Our Ref: P/45/26/NMA

Non material amendment following the grant of P/153/21/RES relating to realignment of part of the road in the northern parcel to facilitate access to the consented site beyond
Land South of Summer Lane and West of Pagham Road Pagham

Title Northern Affordable Housing Plan

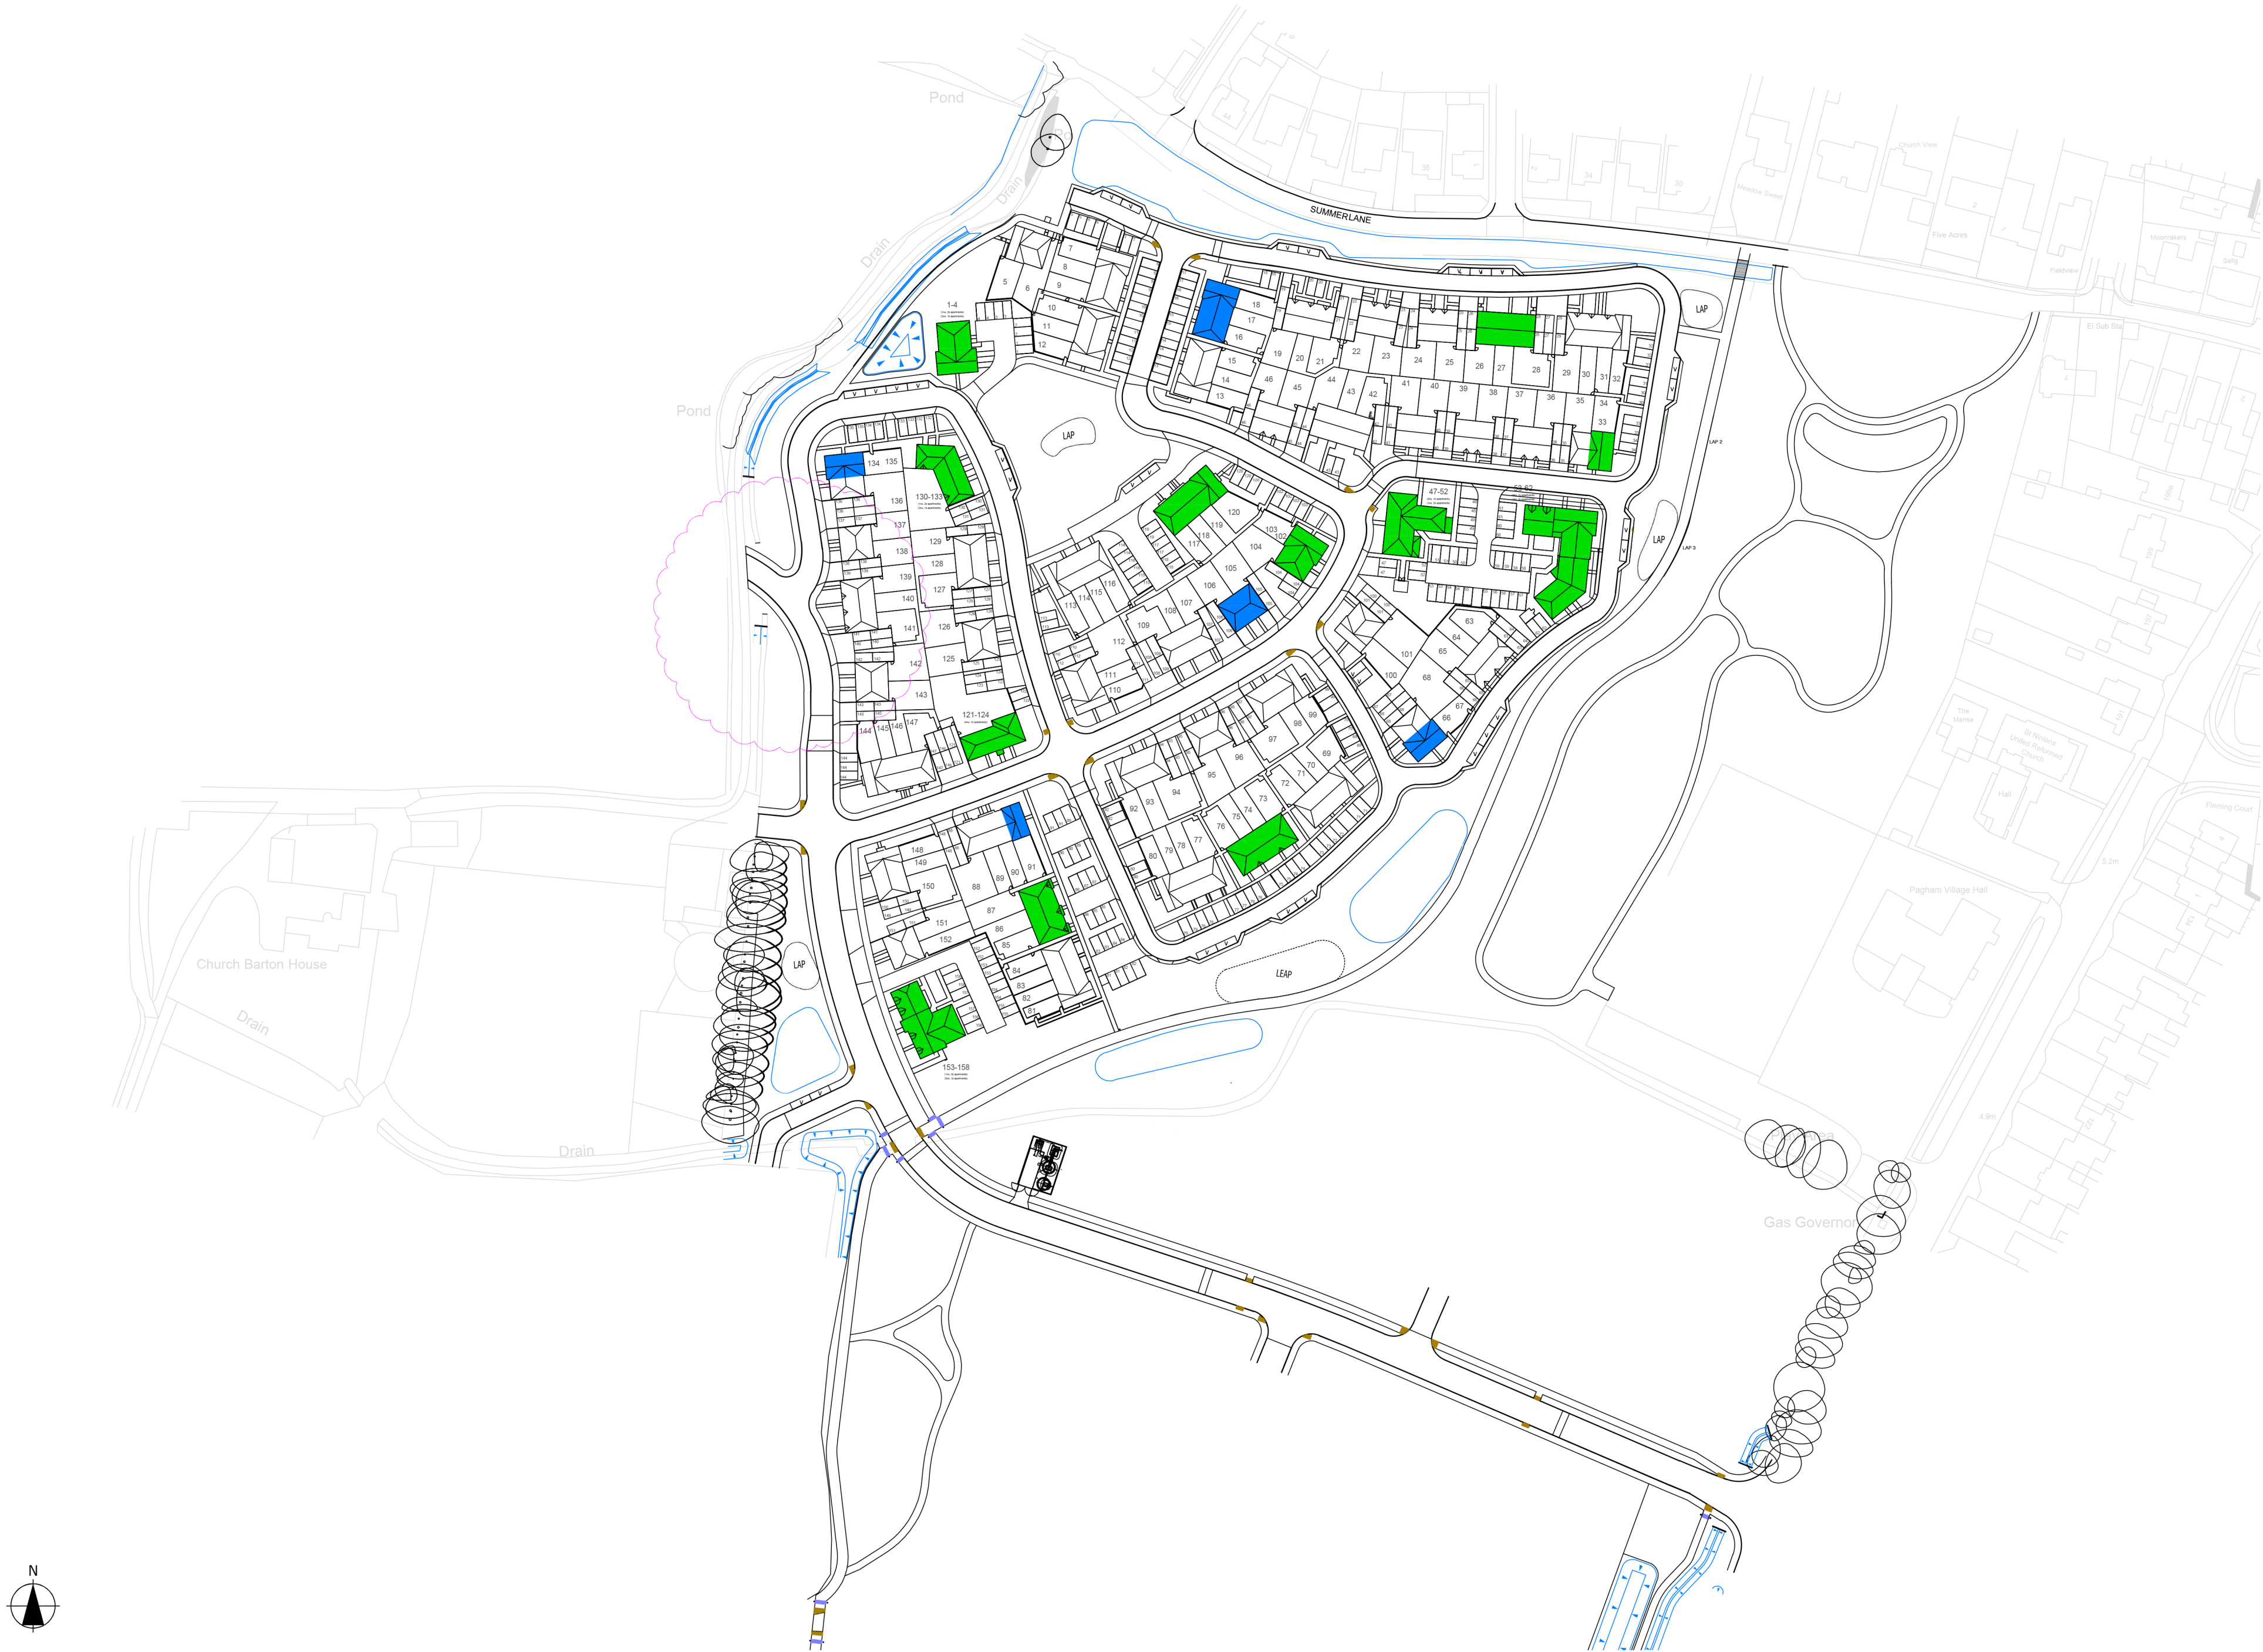
This application seeks to update the approved plans, to include the realignment of part of the road in the northern parcel to facilitate access to the consented site to the west.

At present, the approved plans show this road to be part of the no-through access network to the residential properties in the northern parcel of P/153/21/RES. The amended road would include a new access to the adjoining residential site to the west. When approved in principle under P/140/16/OUT, and then in detail under P/153, this road was assessed on the basis that it was of a sufficient design to serve as access for the quantity of properties in this northern

parcel, with a potential access onto Horns Lane. It was not assessed on the basis of use as access by the neighbouring site, which now has consent. Therefore, it is considered that the use of this road as access to the neighbouring site is a material change to that which was assessed under P/140/16/OUT and P/153/21/RES, and is a material change to the use of the road. This therefore has a material impact on amenity and infrastructure requirements, and requires full review and assessment from the Local Highways Authority (LHA), WSCC Highways to ensure this change is acceptable.

The proposal would see the loss of part of this mitigation planting, rendering its purpose to protect the mitigation land to the west far less effective. As this mitigation measure is proposed to be lost in part, the LPA needs to be confident that this change does not impact the effectiveness of the Brent Geese Mitigation Plan. This would result in a need to consult the ADC Ecologist and Natural England, to ensure that this change does not significantly alter that which was agreed under the Appropriate Assessment, nor undermine the purposes of the plan.

As such, resultant of the realignment having a material change to the use of the road, incurring the need for a consultation with WSCC Highways; and resulting in a potential impact to the Brent Geese Mitigation Plan, this amendment cannot be accepted as a Non-Material Amendment. This change will therefore need to be considered under a Section 73 application, where relevant consultees can be consulted, and the full impacts to amenity, infrastructure and ecology can be assessed.
